Project Name: Mister Car Wash

98th Street and Volcano Rd.

**RE: MISTER CAR WASH – 98TH AND VOLCANO
GRADING AND DRAINAGE PLAN RESPONSE TO COMMENTS
ENGINEER'S STAMP DATE**

Per your correspondence dated March 25, 2019 please find the following responses addressing the comments listed below.

MISTER CAR WASH
98TH ST & VOLCANO RD
EROSION CONTROL AND
SEDIMENTATION PLAN

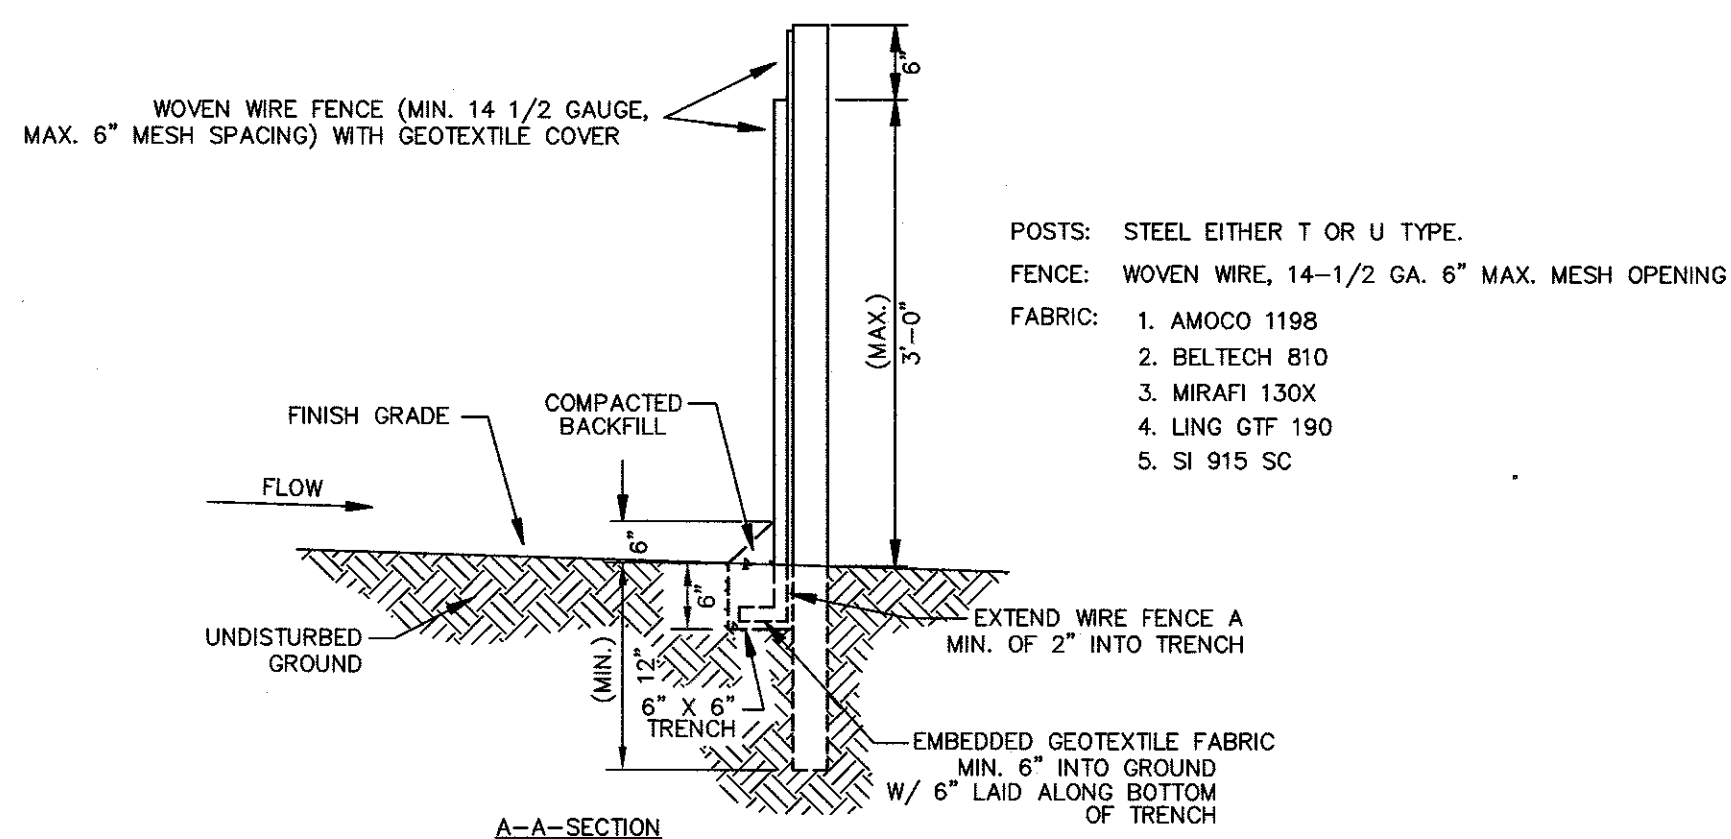
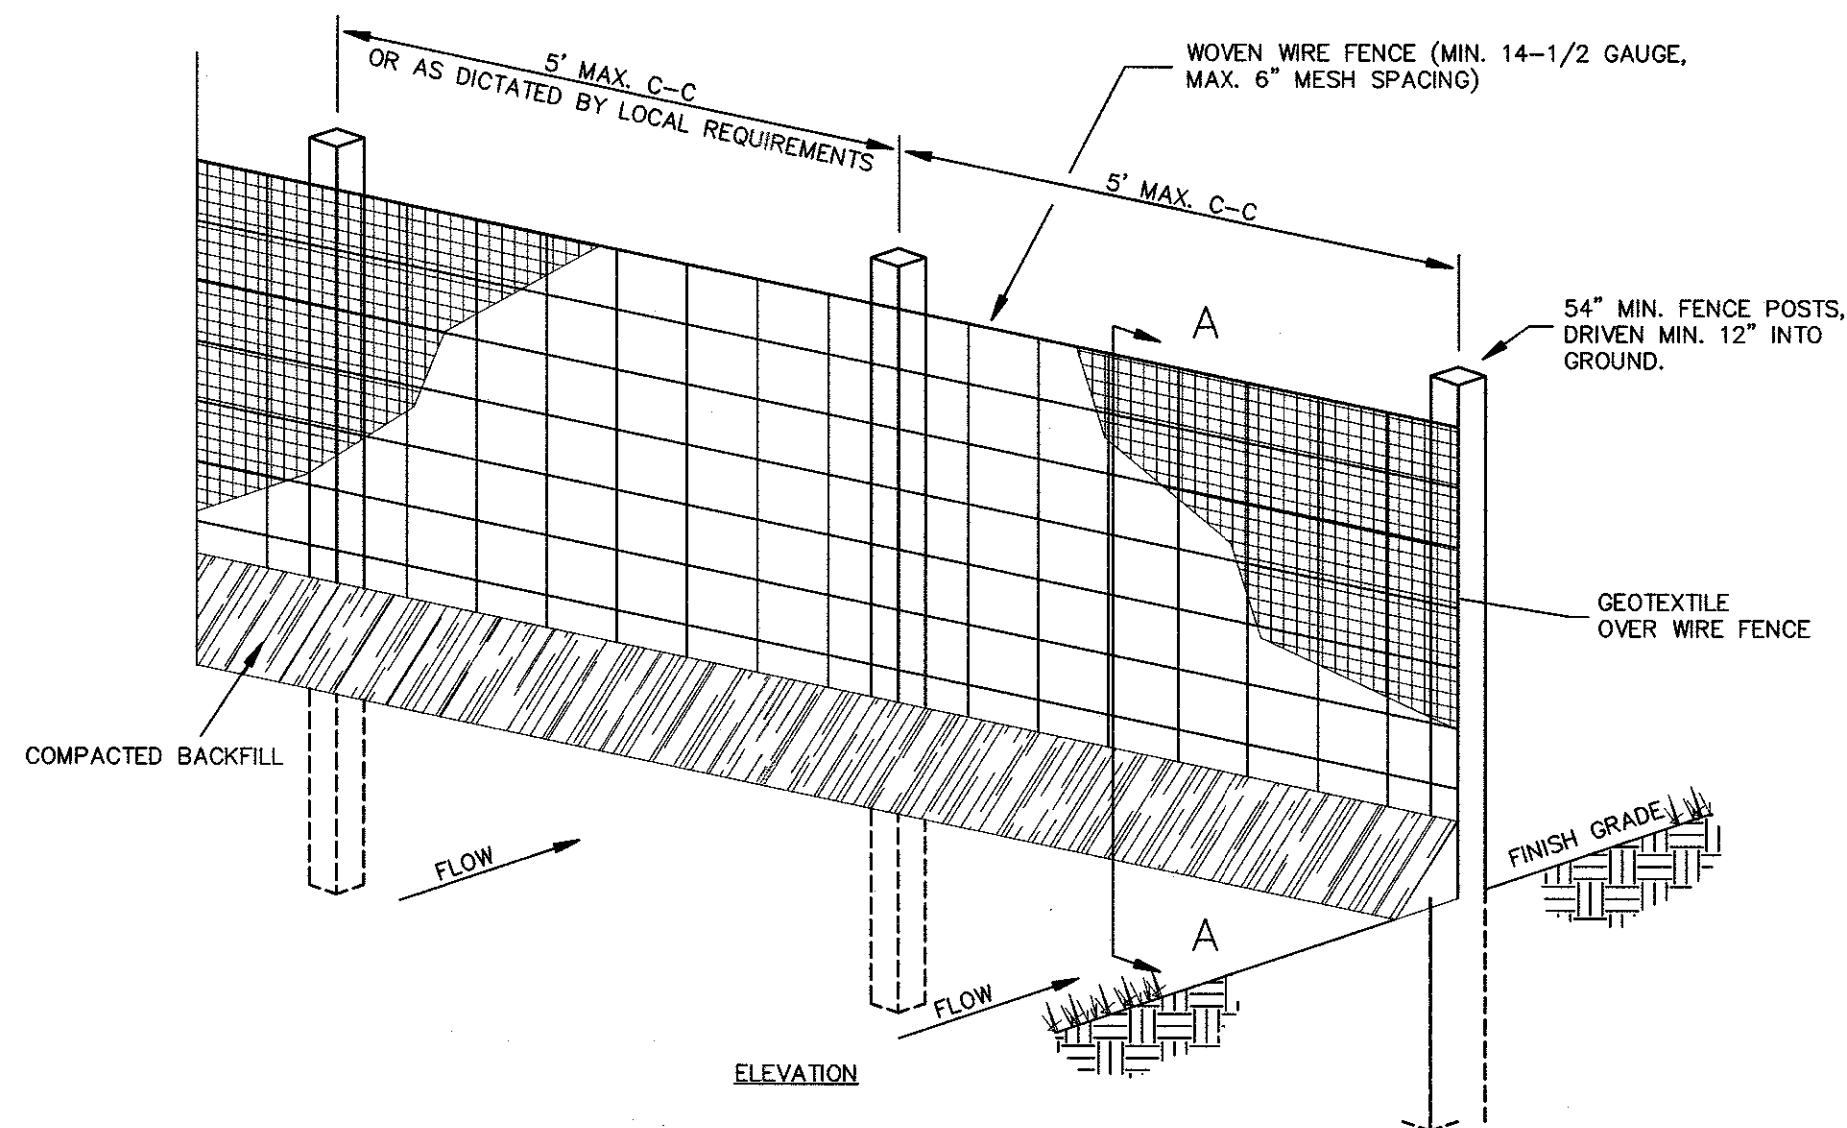
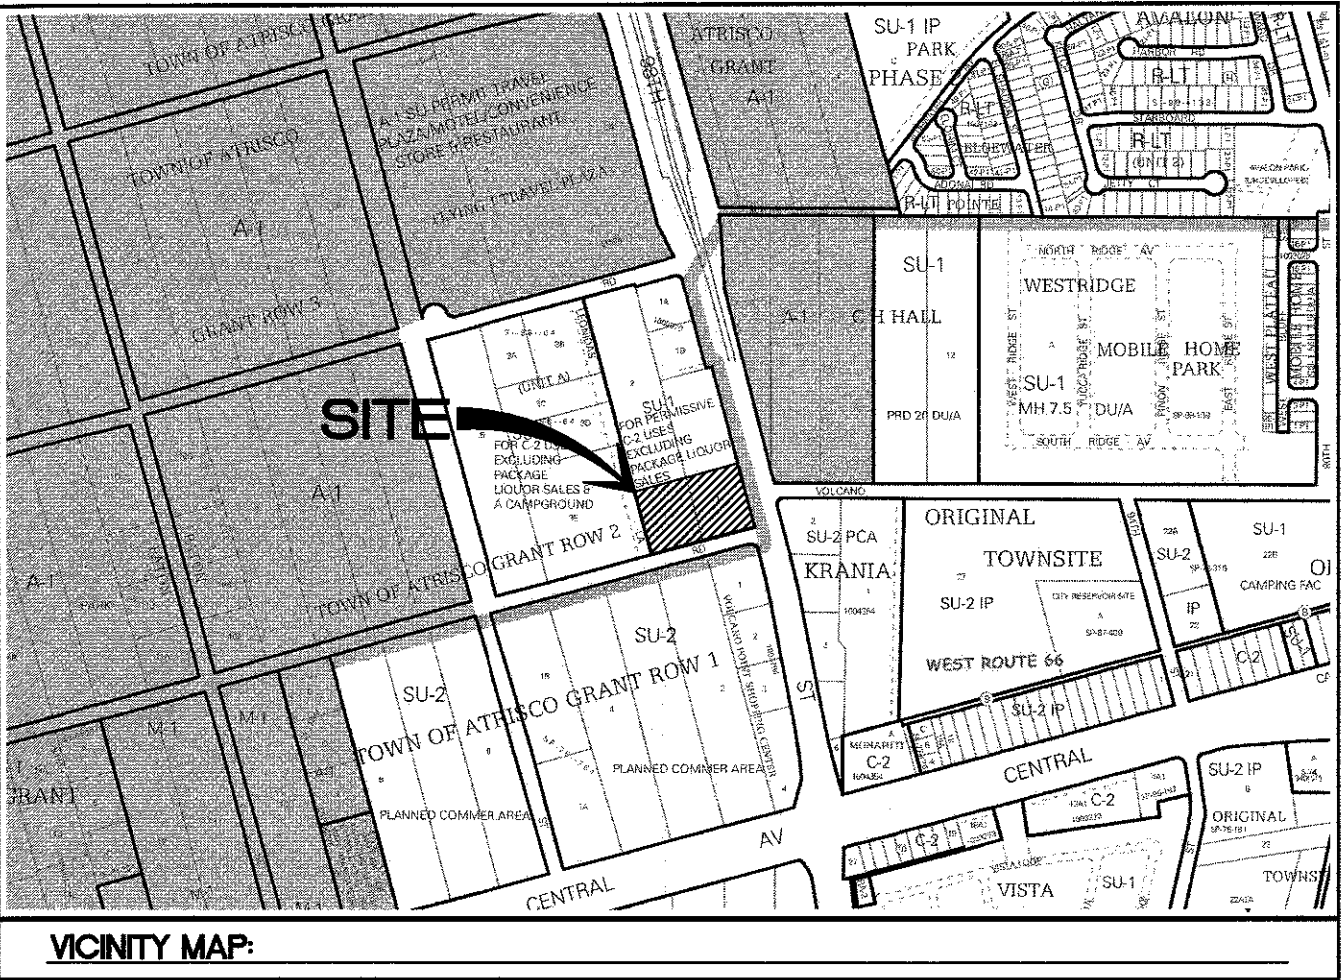
1. Clearly show the limits of disturbance including the area to be disturbed by the Work Order
Response: The limits of disturbance have been clarified by
2. Clearly add a perimeter control along the low side of the project like Silt Fence
Response: Silt Fence has been added to the downstream side of the site.
3. Clearly add inlet protection at the pond outlets and inlets in the public ROW.
Response: Inlet protection has been added to outlets and inlets.
